Application No. H14/0357/03/A1
Date Registered 22 JUL 2003
Case Officer PJU

PROPOSED EXTENSION AND WORKS
TO HOUSE AND ADJ. BARN.

Amendment: Increase width of rear extension & replace utility window with back door.

TOWN AND COUNTRY PLANNING ACT 1990 NOTICE OF ACCEPTANCE OF AMENDMENT

Ref. A1

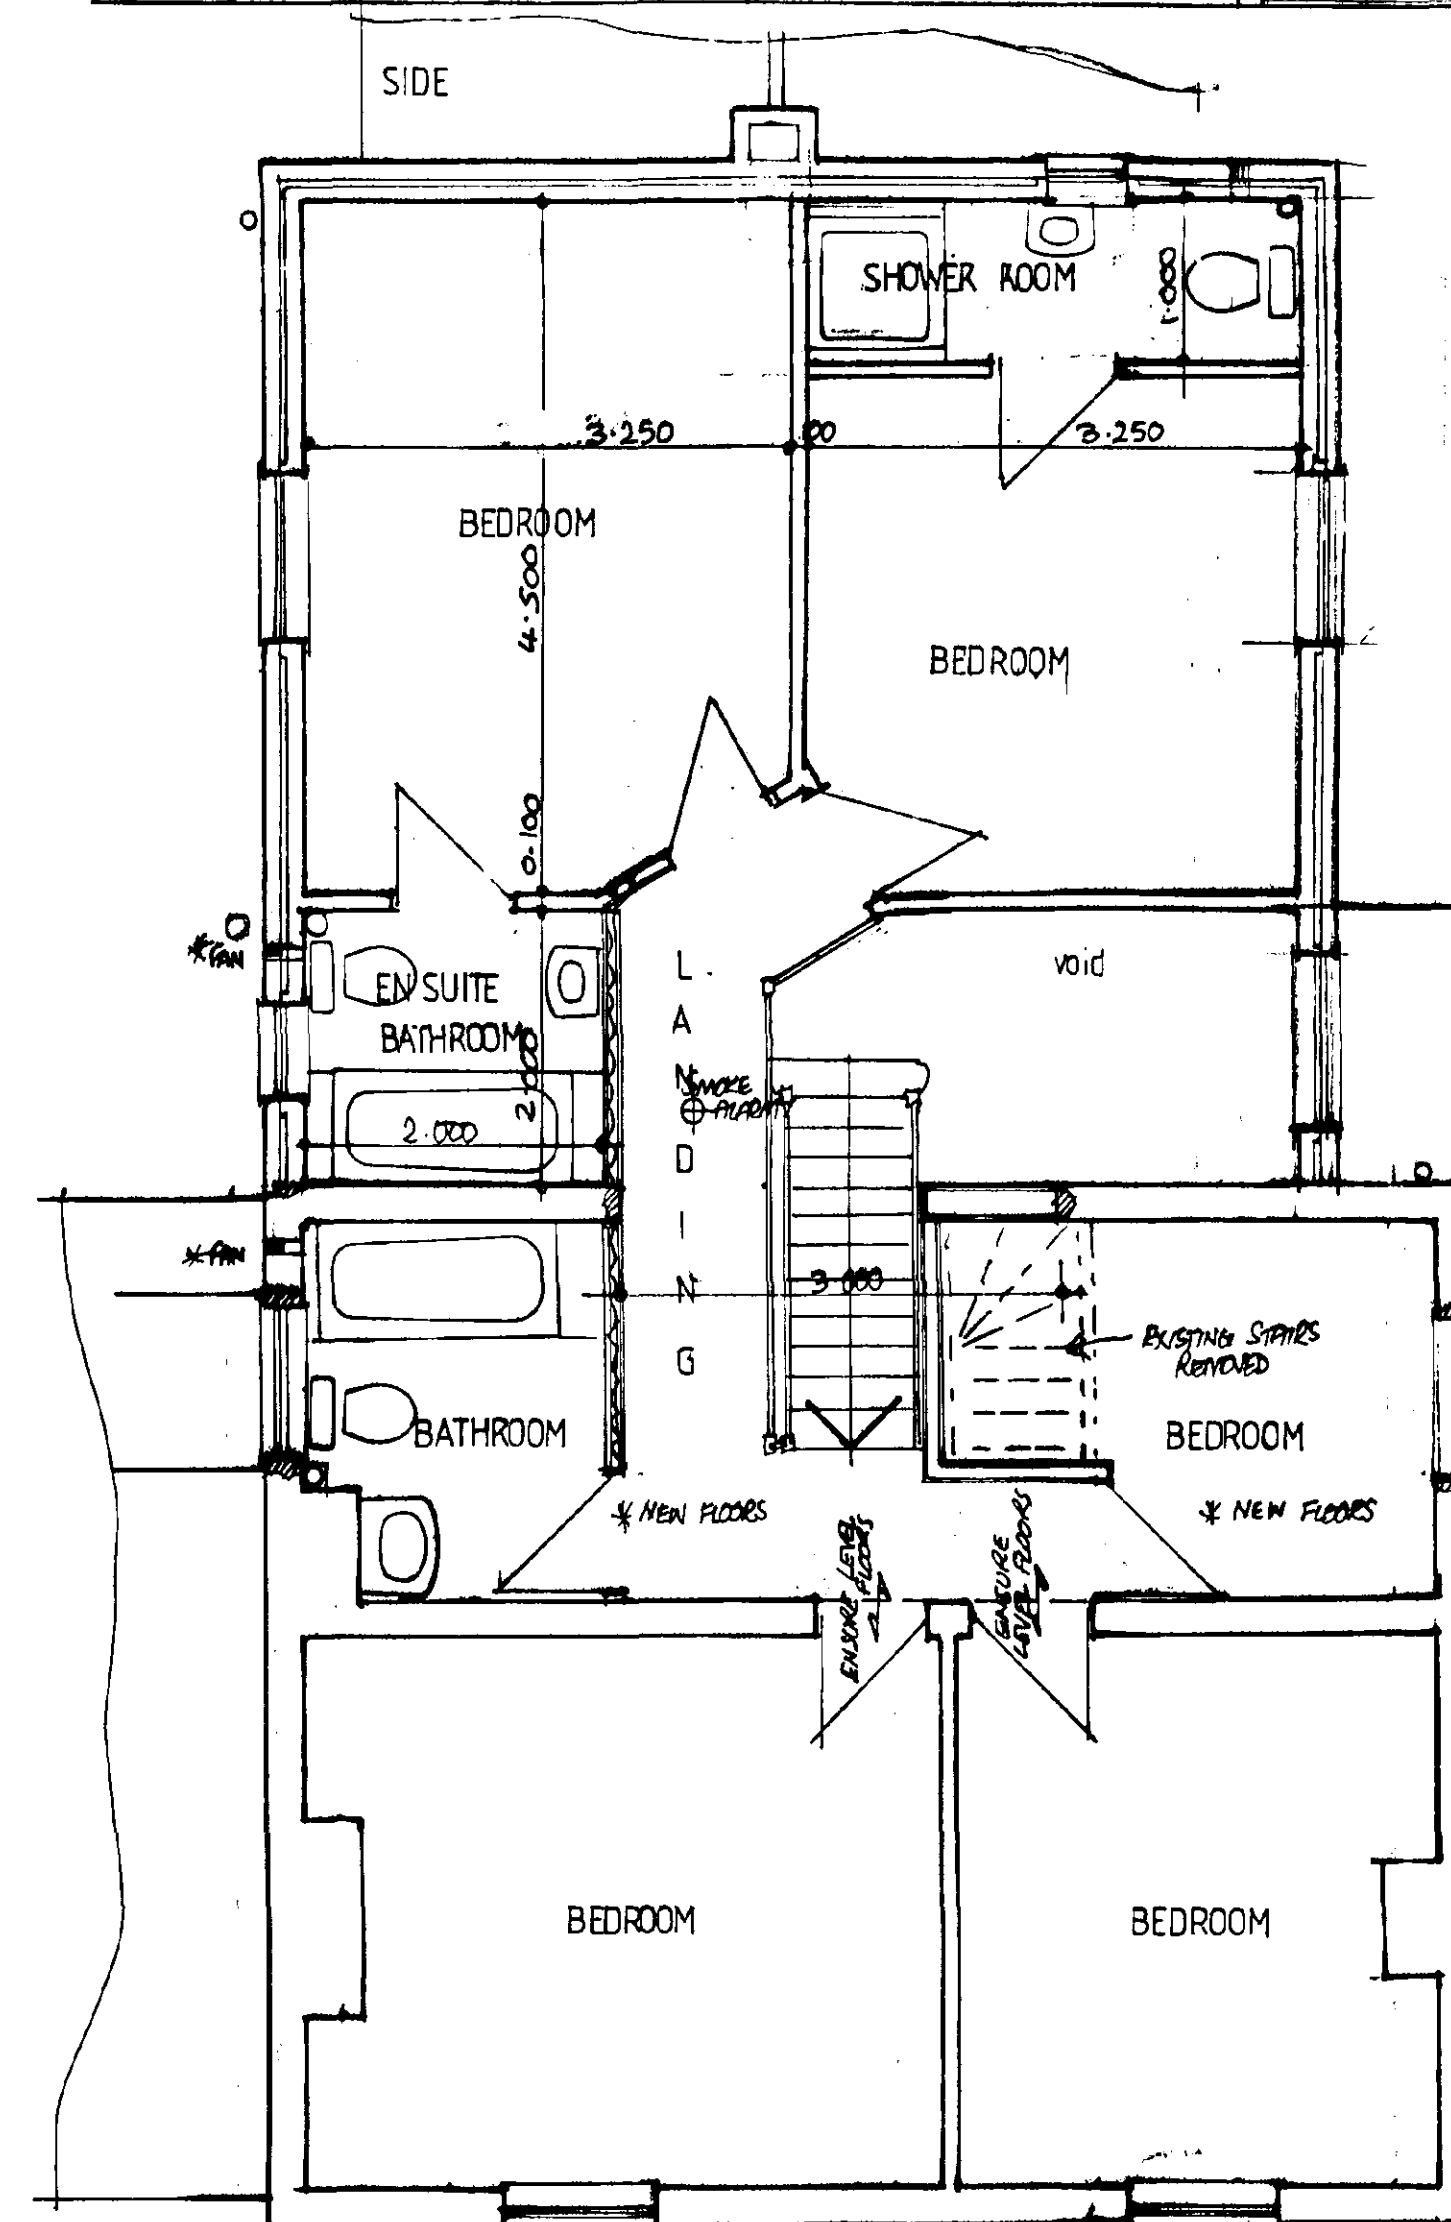
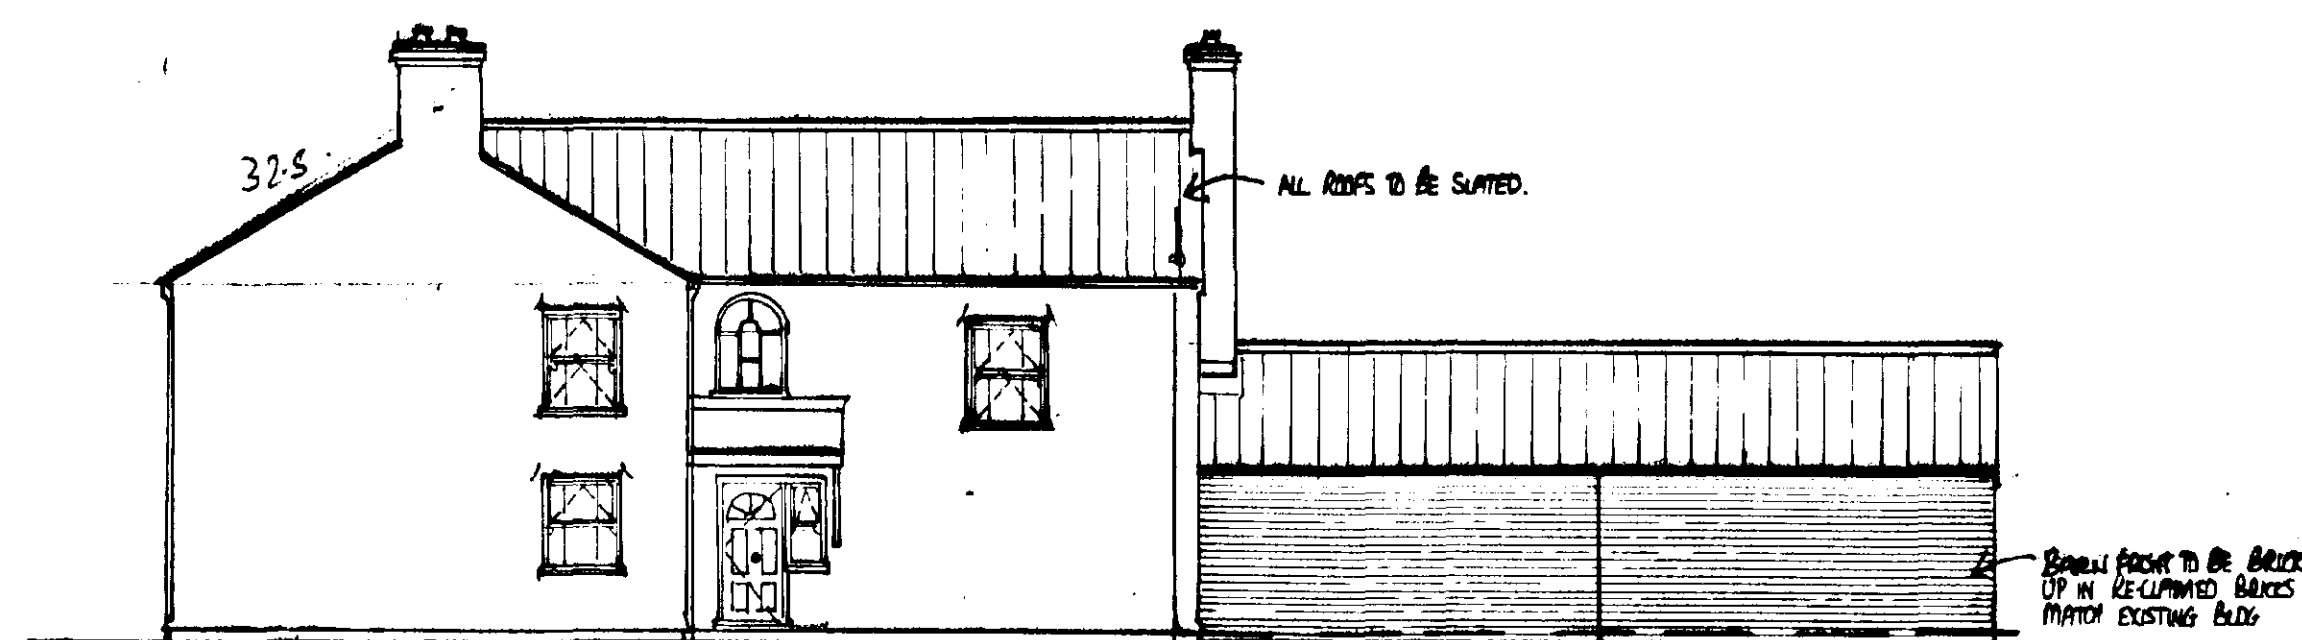
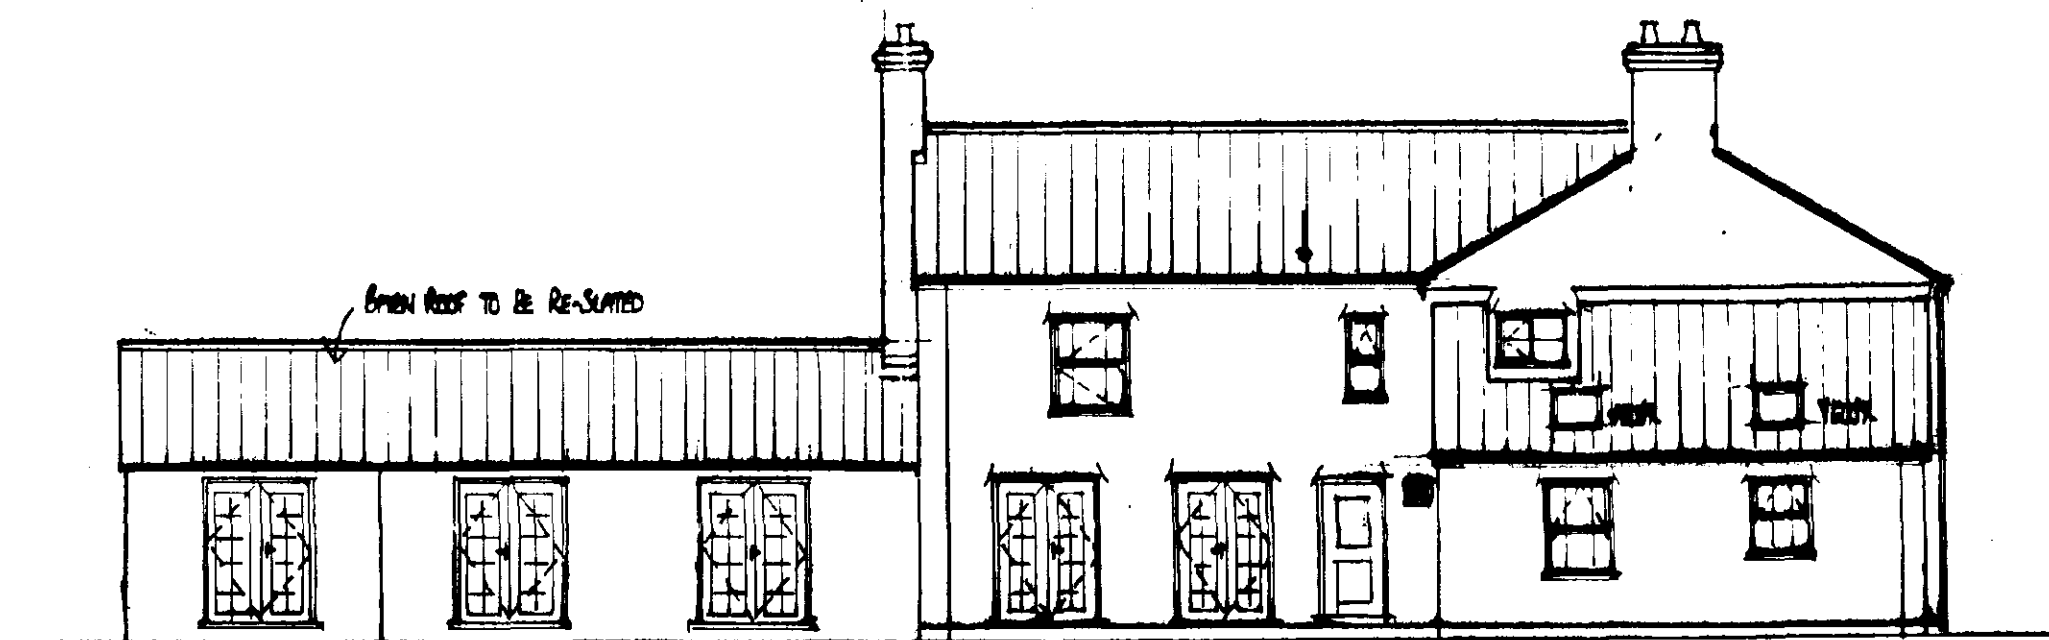
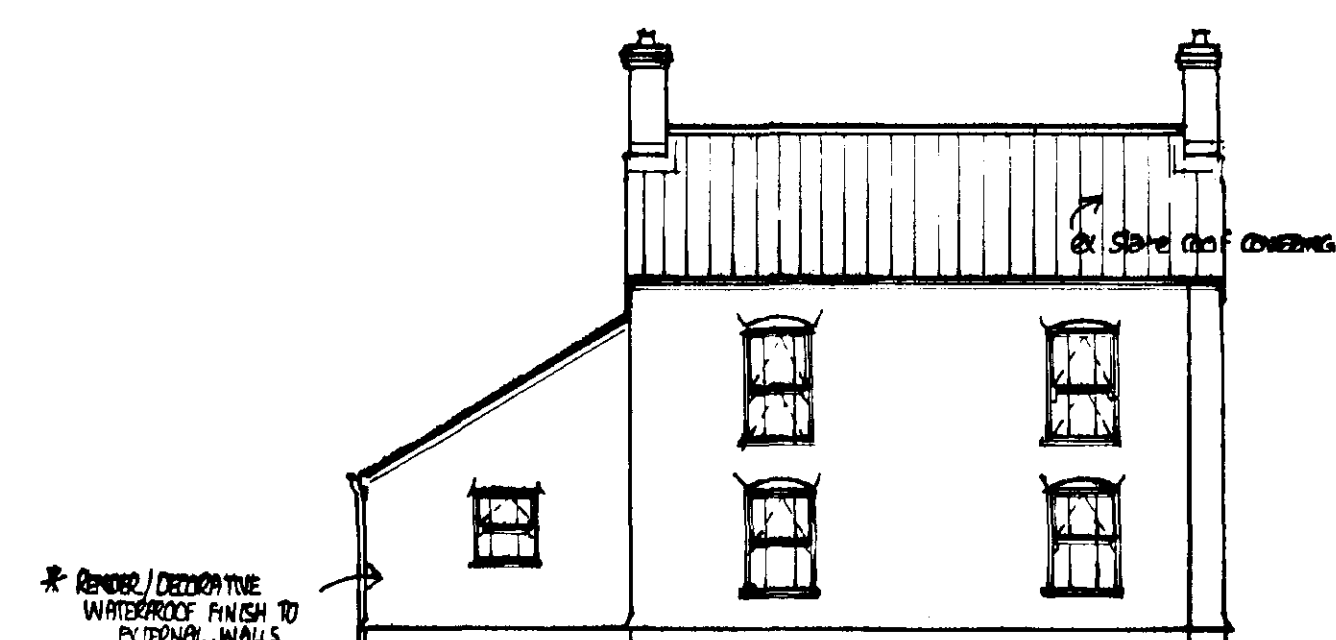
WIDTH OF REAR EXTENSION
INCREASED.
WINDOW TO UTILITY REPLACED
WITH BACK DOOR.
